Our Case Number: ABP-314724-22

Re: Railway (Metrolink - Estuary to Charlemont via Dublin Airport) Order [2022]
Metrolink. Estuary through Swords, Dublin Airport, Ballymun, Glasnevin and City Centre to
Charlemont, Co. Dublin

Railway (Metrolink –Estuary to Charlemont via Dublin Airport) Order [2022] 314724-22

Figure 2: Proposed Drop off Profile adjacent to the Grand Canal.

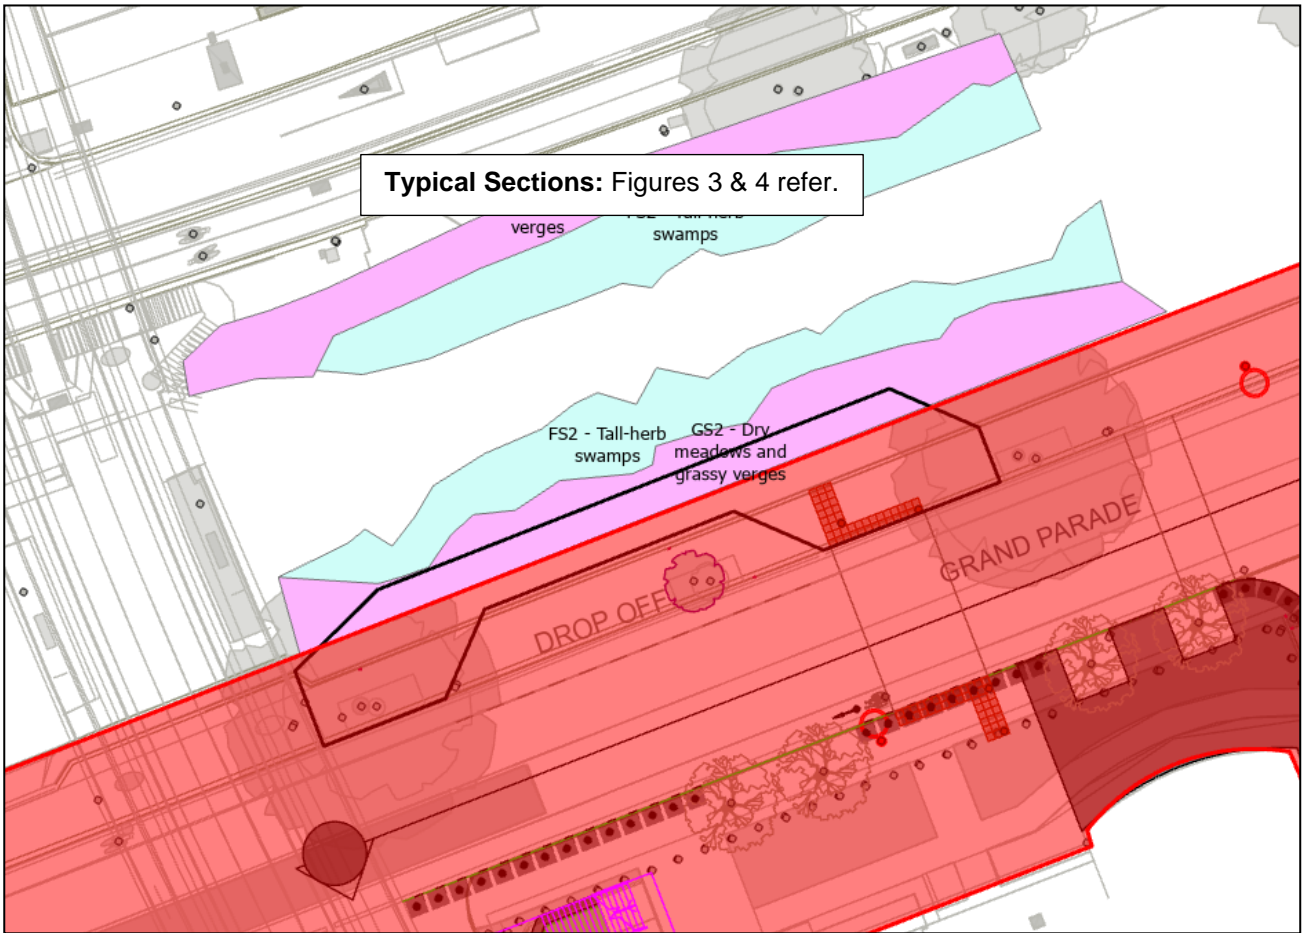
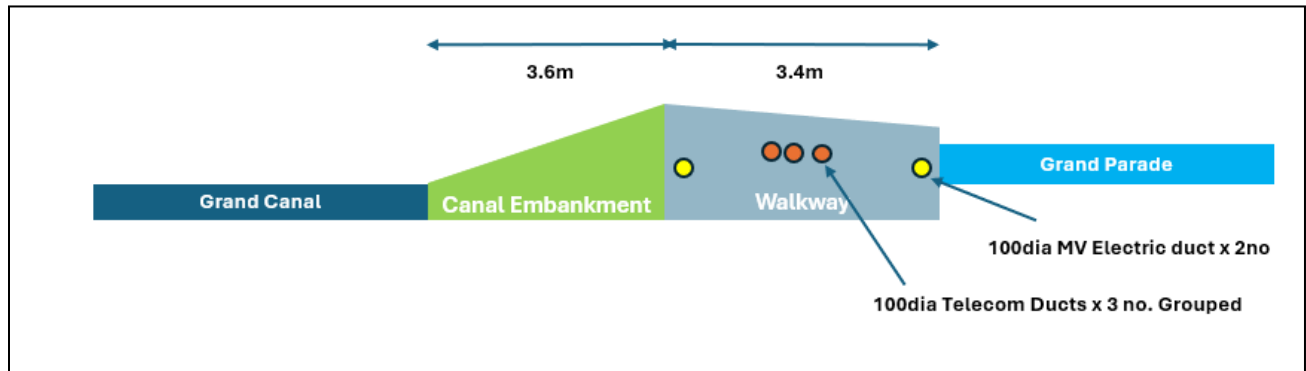
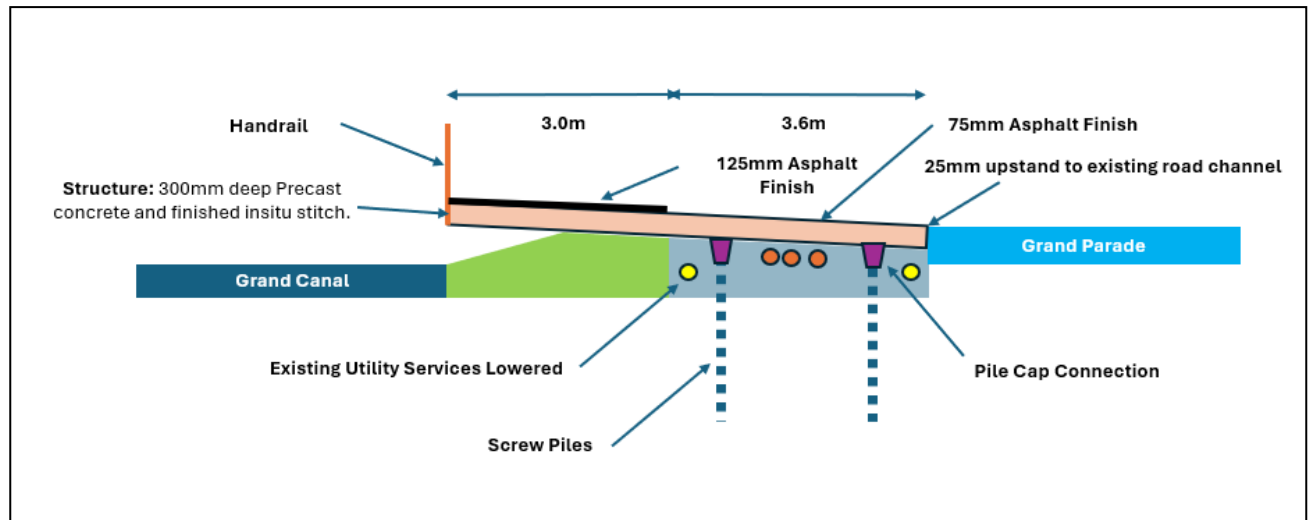
I think it is highly unsatisfactory that at the opening of the oral hearing a new proposal was introduced for a walkway jutting out over the canal. It seemed blindingly obvious to me that there was simply not enough space to accommodate a two carriage roadway, a lay by and a pedestrian walkway, without intruding into the canal. This is another example of a poorly considered approach to the above ground issues at Charlemont.

I don't think adequate note has been taken of the use of that area of the canal by wildlife. The day 1 book 5 document is clearly inadequate as it accepts at page 11 that "this is the incorrect time of year to habitat map". If the applicant had not failed to identify that the canal area was required, there would be a proper survey. Their inattention should not allow them get out of a proper process. The updated report has not really addressed the deficiencies.

The lay by that this facilitates seemed to itself present problems and the Bord should consider its omission and the consequent omission of the canal structure.

Figure 5: Union Proposed Location of Luas Access Lift

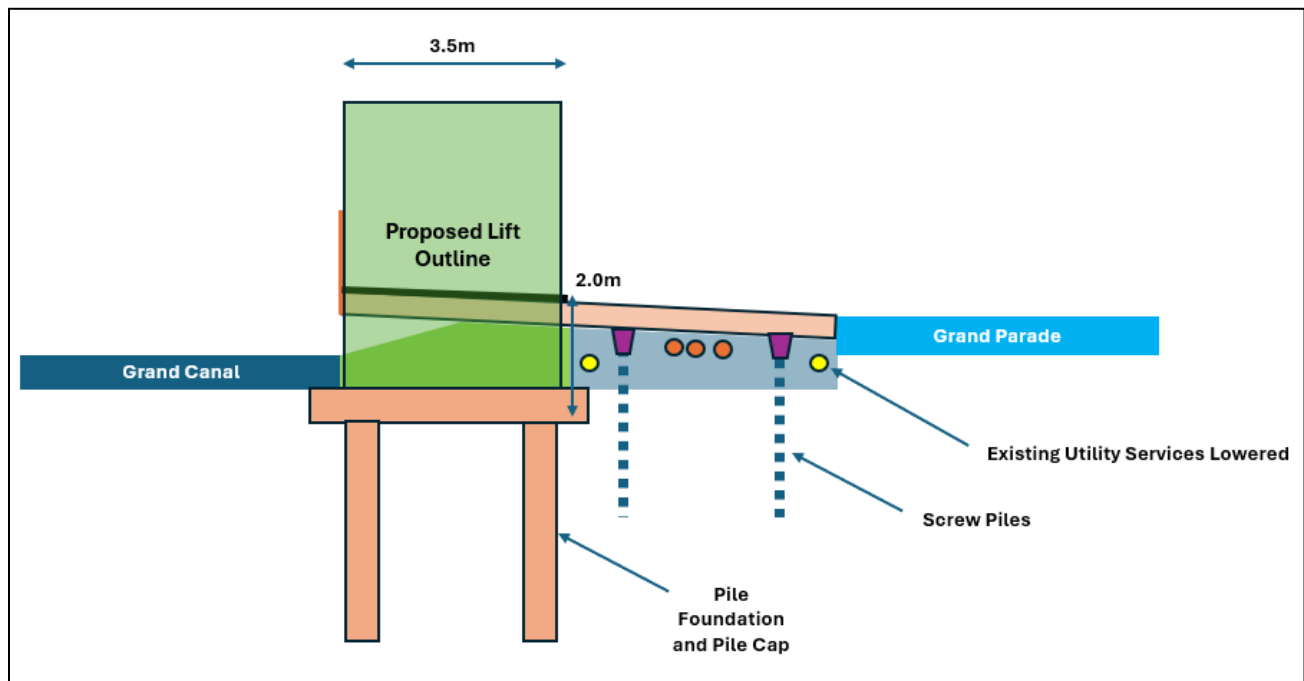
Another key issue is the location of the Carrolls Building Stairs and Lifts. While this takes up a lot of airtime, it is in my view much less important than the stairs being manifestly unfit for purpose. It is clear that the owner of the building has significant issues about a stairs in front of its premises as they have suggested the infrastructure ought to be moved to the canal side of Grand Parade. The day 21 document "Carrolls Building Stairs and Lift" in section 5.0 accepts that *"The provision of a lift, stairs and a widened pavement will be mitigated by design to reduce the impact on the protected structure. Following mitigation the impact will be significant"* This document trivializes (*"potential for overlooking"*) the issues of huge numbers of people walking by offices at floor 1 and 2 of the building, which affects about a third of the length of the building. The document seems to suggest that the owner (Union Investment Real Estate) might want the lift moved; I think the substance of their submission is that the stairs be moved to the canal side.
